Appeal Decision

Appeal Ref: APP/R5510/D/21/3270657

51 Ickenham Road, Ruislip HA4 7BZ

Drawing Content:
Proposed Elevations

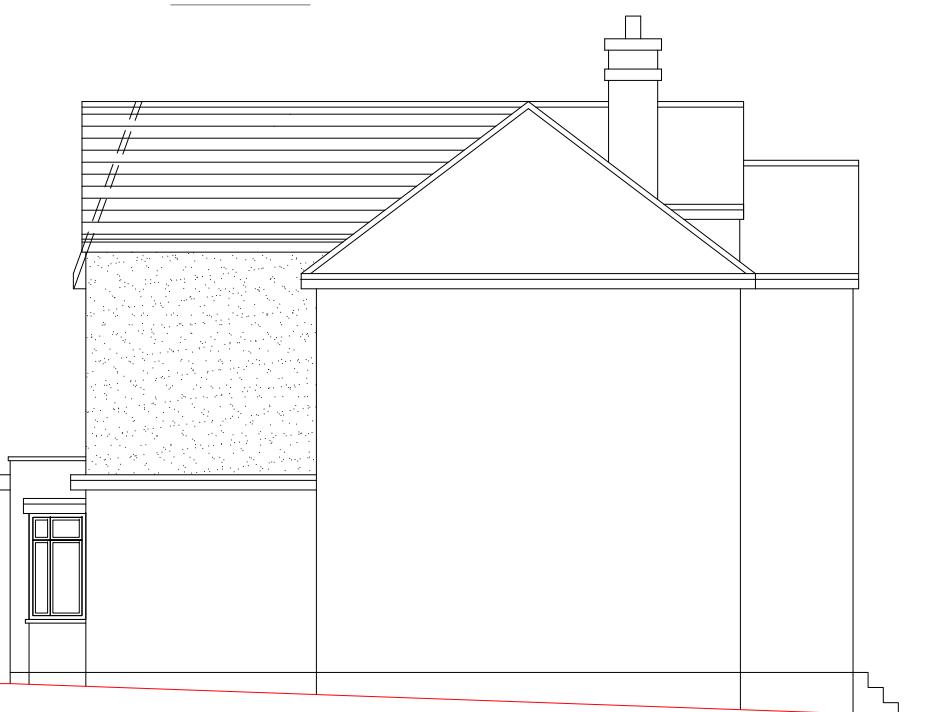
4. The gable features of the proposed extension would reflect the rear elevation of the existing property. The roof planes of those structures would be a similar pitch to the original roof of the dwelling. By comparison, the proposed crown roof element, between these gables would include an extremely steep pitch which would be at odds with the existing roof form. This pitch would be almost vertical, giving this part of the proposed extension a bulky appearance, which would fail to harmonise with the host dwelling.

5. I note the proposed extension would include materials to match the existing dwelling, but this would do little to reduce the visual impact of the proposed crown roof design detail. Whilst the proposed extension would not be visible within the street scene, and it would be a relatively small design feature, there would be views of this incongruous detail from neighbouring properties.

6. Planning consent for a similar extension to the host dwelling was allowed at appeal in 2018¹. However, the crown roof element of that scheme was significantly shallower than that of the current proposal and better reflected the existing roof pitch of the main house. The previous scheme would therefore have harmonised well with the appeal dwelling, unlike the development before me. I therefore attach limited weight to this matter in support of allowing the appeal.
